From: Martyn White <Martyn.White@arun.gov.uk>
Sent: 29 April 2022 15:05
To: Obafemi Okusipe <Obafemi.Okusipe@arun.gov.uk>
Subject: FW: RE: LU/411/21/PL 90-91 South Terrace, Littlehampton

Just to clarify my comments below, I am happy with the revised designs as they now reflect the previously approved scheme and deal with my objections regarding the use of materials. The use of bricks and clay tiles means that the scheme is now acceptable

project Proposed Development 90-91 South Terrace Littlehampton, W Sussex		
detail 1st Floor & 2nd Floor Plans	drawn MAS	checked
date Nov 2021	status Planning	rev C
a1 scale 1:100	a3 scale 1:200

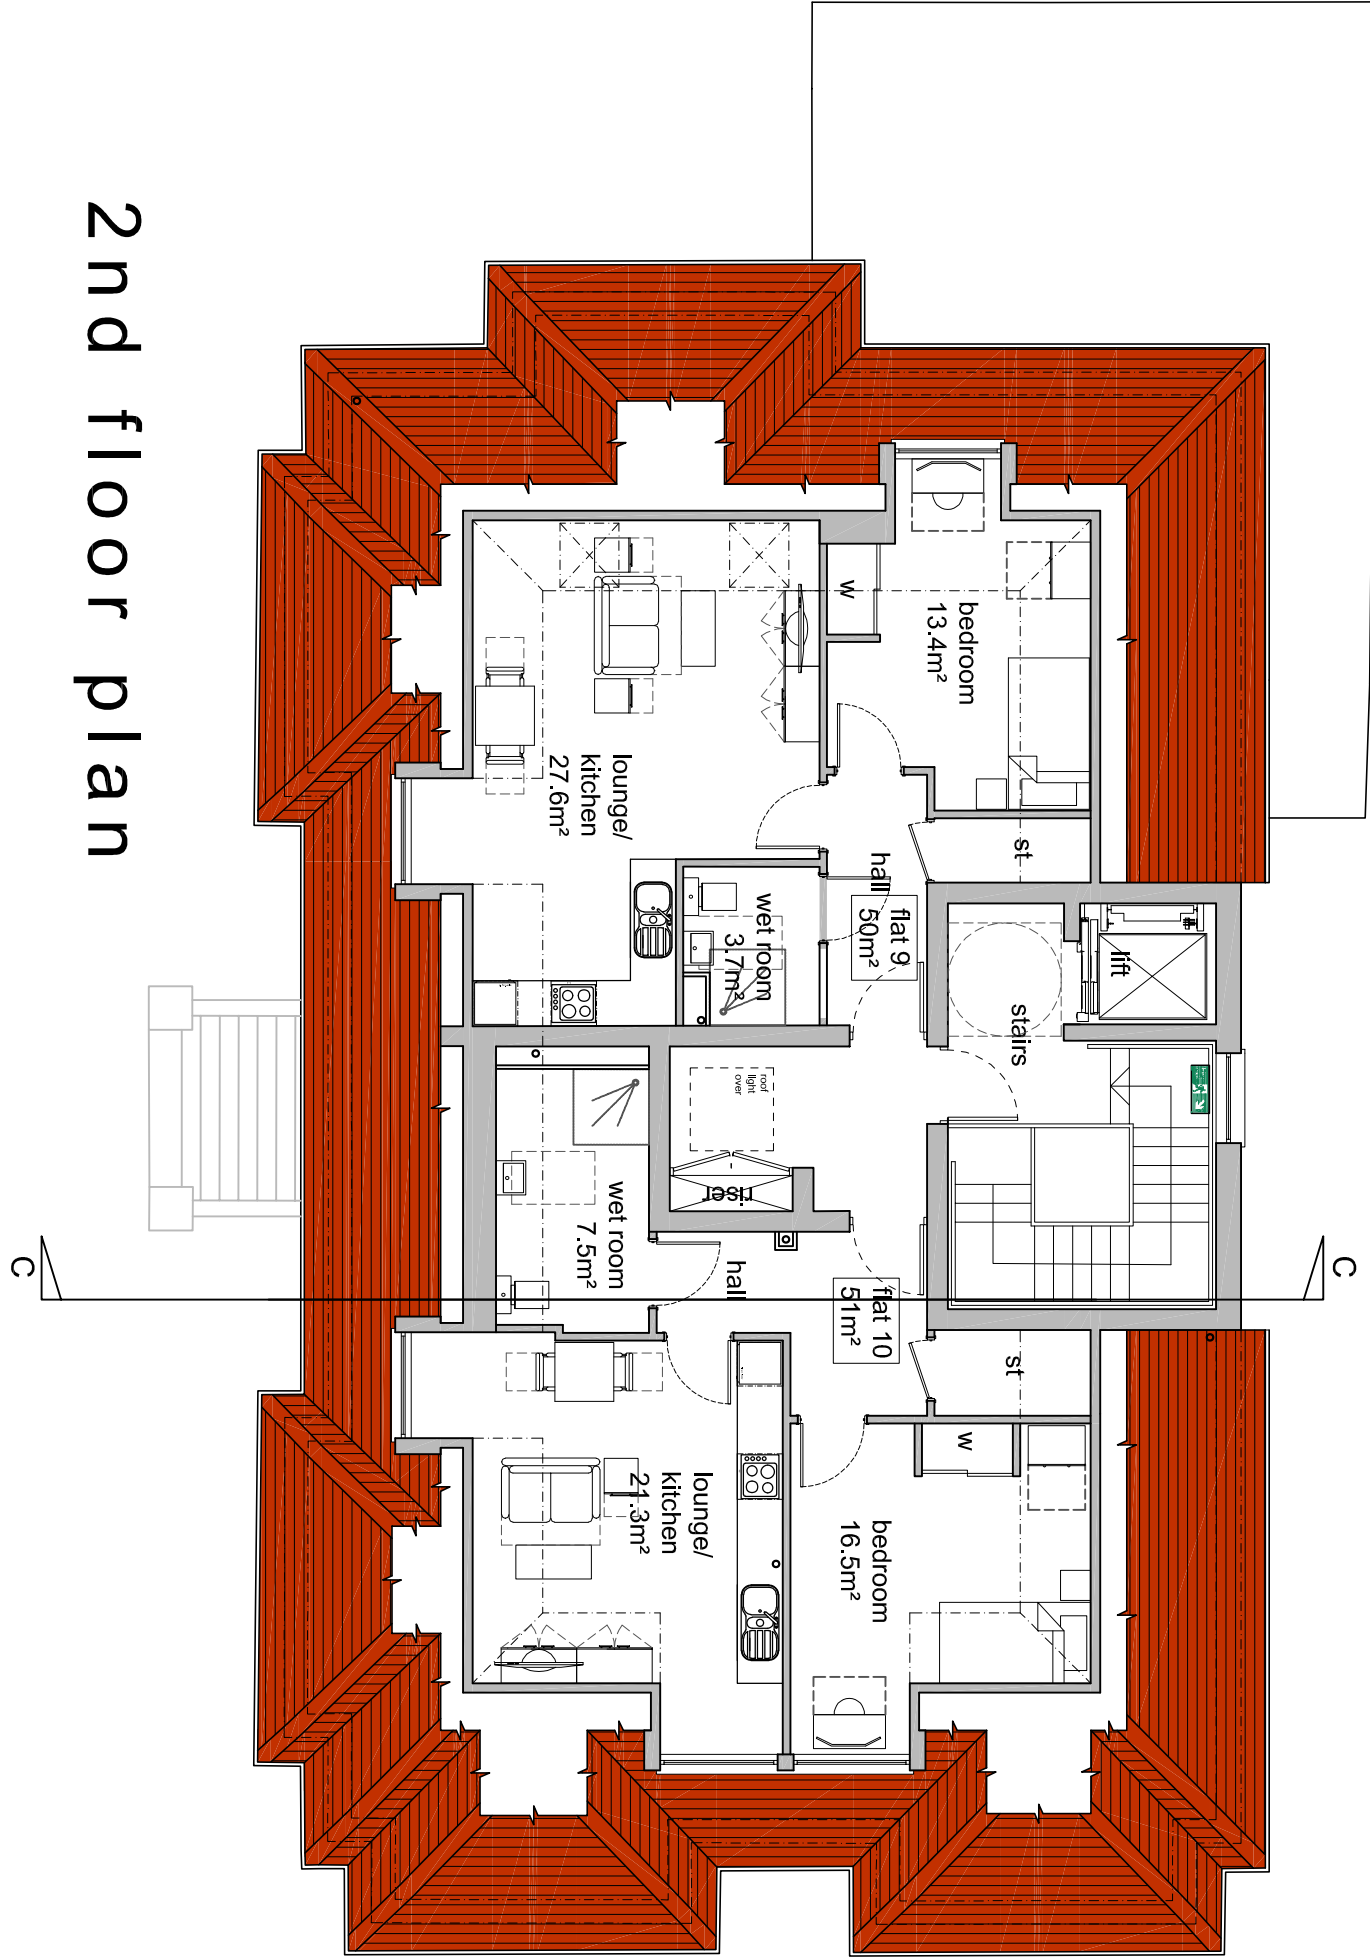
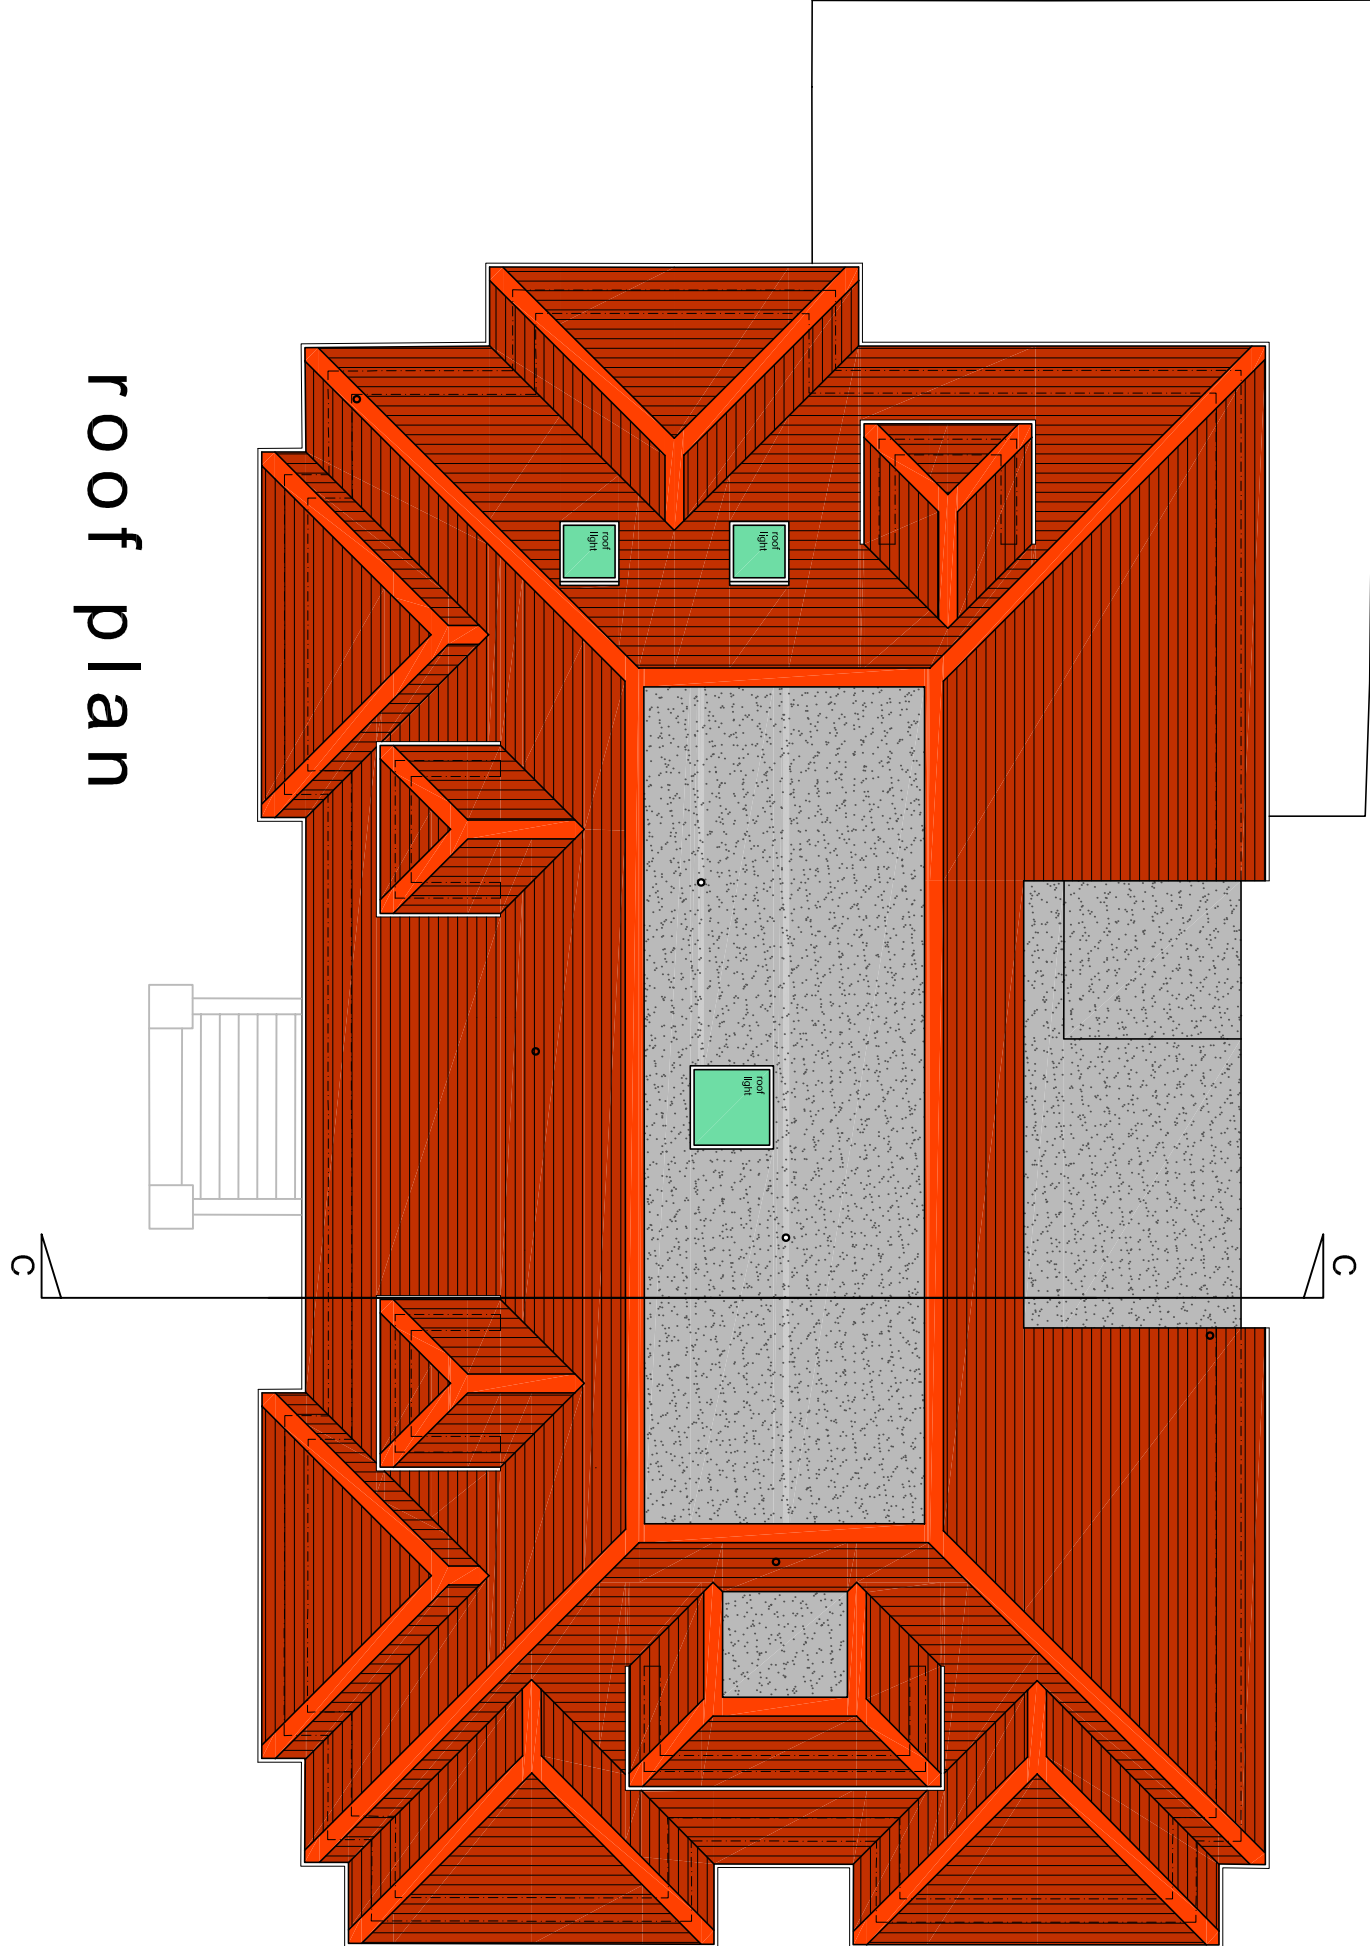
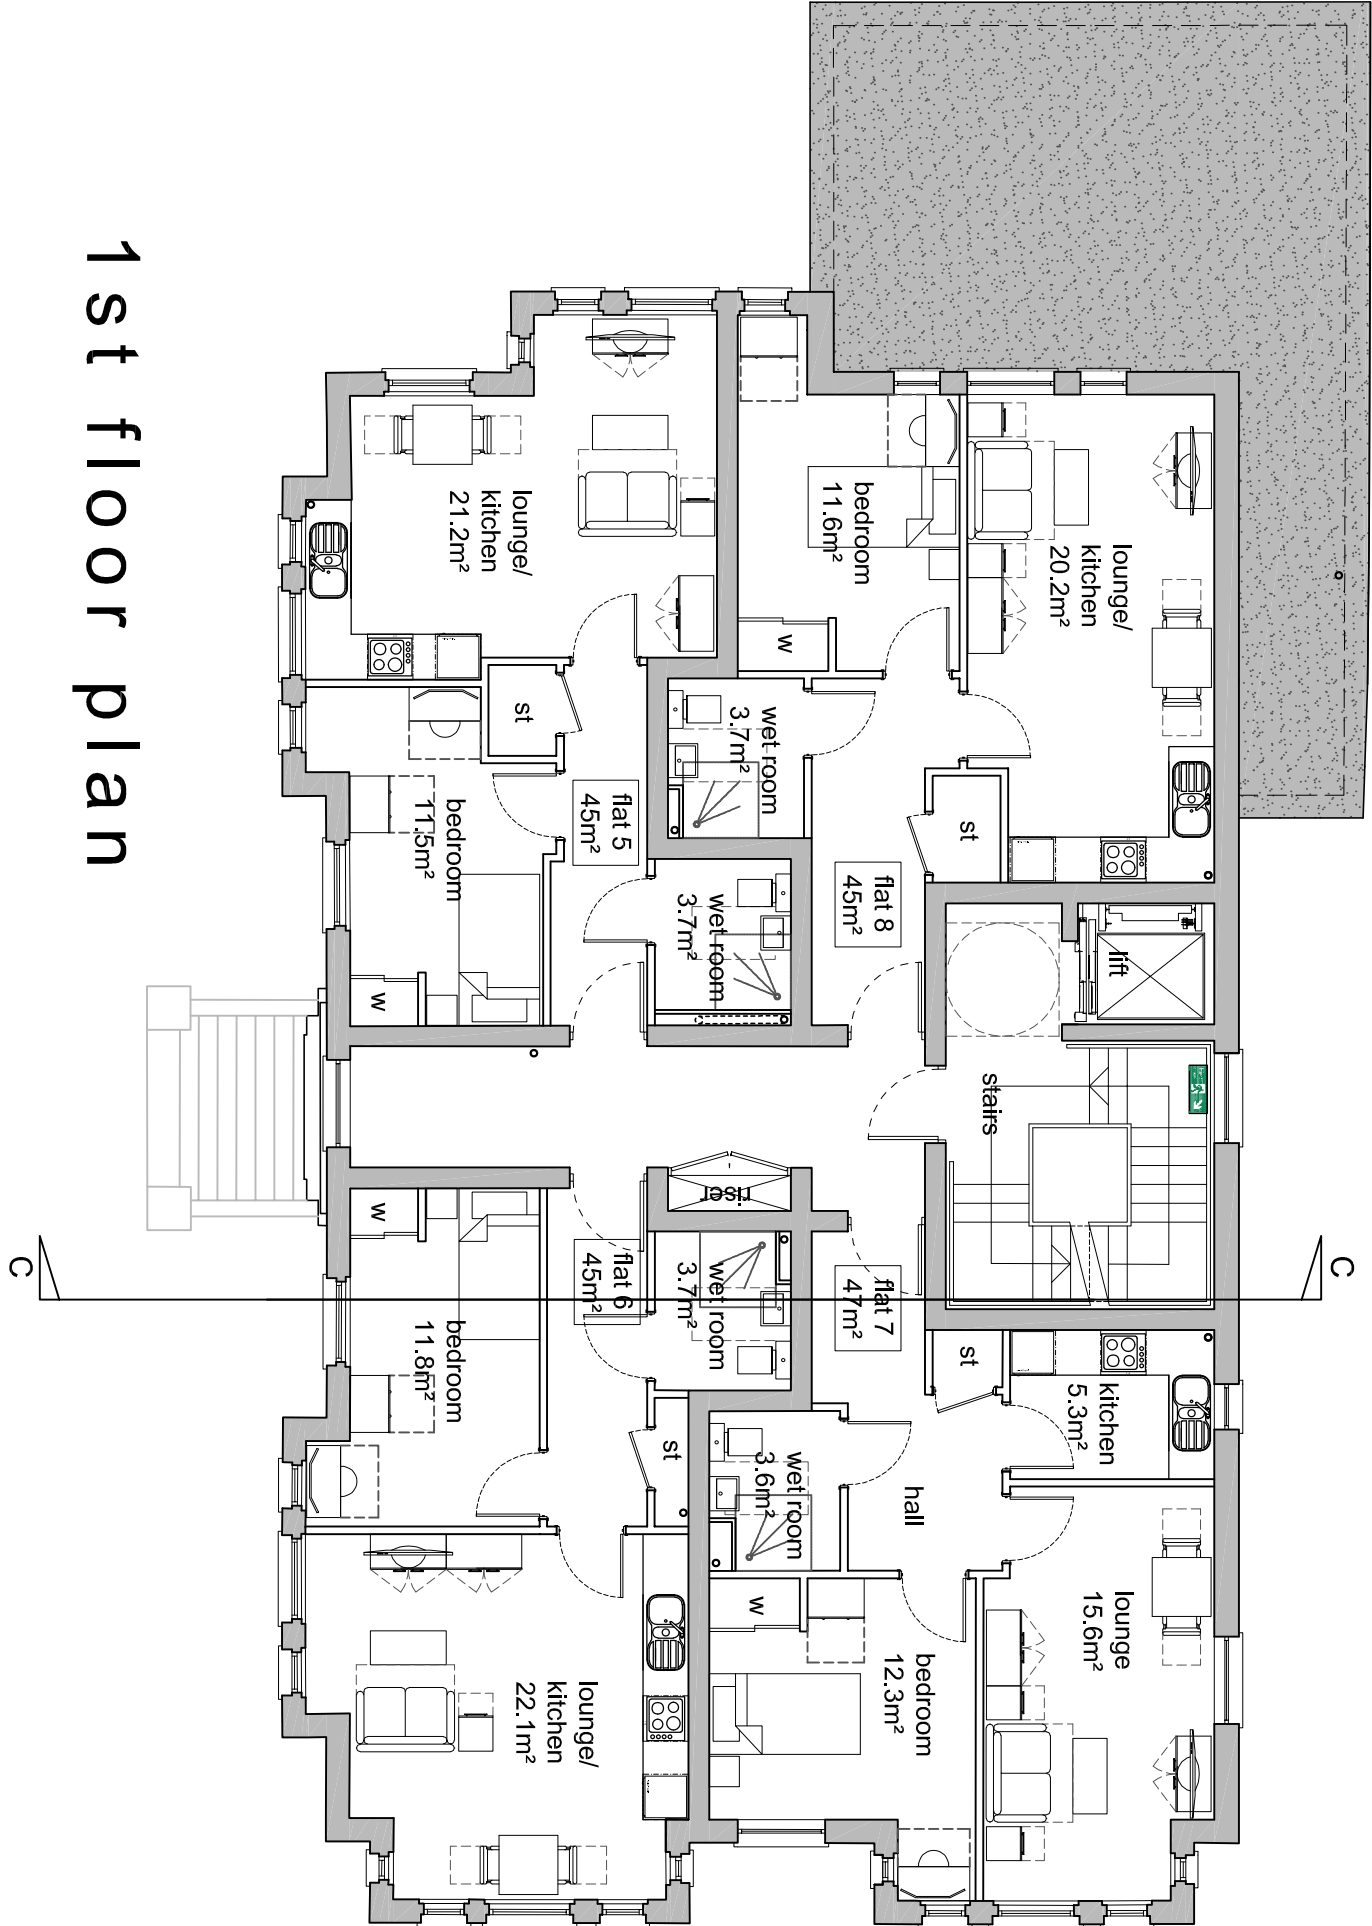
Render to the first floor (to match that of the neighbouring terrace) was chosen as my client, the contractor felt it would difficult to match the new brickwork above the existing given the existing is 100 years old and weathered accordingly. We felt the join between old and new could appear obvious and detract from the finished aesthetic and details such as the creasing tile headers over windows would be difficult to recreate using modern construction techniques. Use of a sand/ rough render finish at this storey height would match with the same storey finish on the terrace to the east of the proposal, so is not out of keeping with the adjacent street scene

Another reason for utilising render on this new additional storey is the construction to the new upper floors is to be lightweight construction to assist in reducing load on the existing structure, a render finish would enable a lightweight supporting structure to reduce weight. The use of a render would acknowledge the fact this is an evolution of the building. The render would only be to the 1st floor so would be at the same storey as the render on the 1st floor of the adjacent terrace (see photo below).

The use of slate roofing was proposed to lessen the loadings on the structure but, I'm inclined to agree with your comments that this perhaps a departure too far from the adjacent material finish, and so the reinstatement of a clay tile finish may be more appropriate and would better justify the brick lower storey, render upper storey, clay tile roof scape that can be seen on the neighbouring terrace.

However having discussed this matter with my client, who is keen for this project to progress, I attach drawings which show the render omitted and full height brickwork shown as per the previously approved plans and in accordance with the conservation officers requirements.

Also shown are clay roof tiles, again in accordance with the approved plans and conservation officers comments.
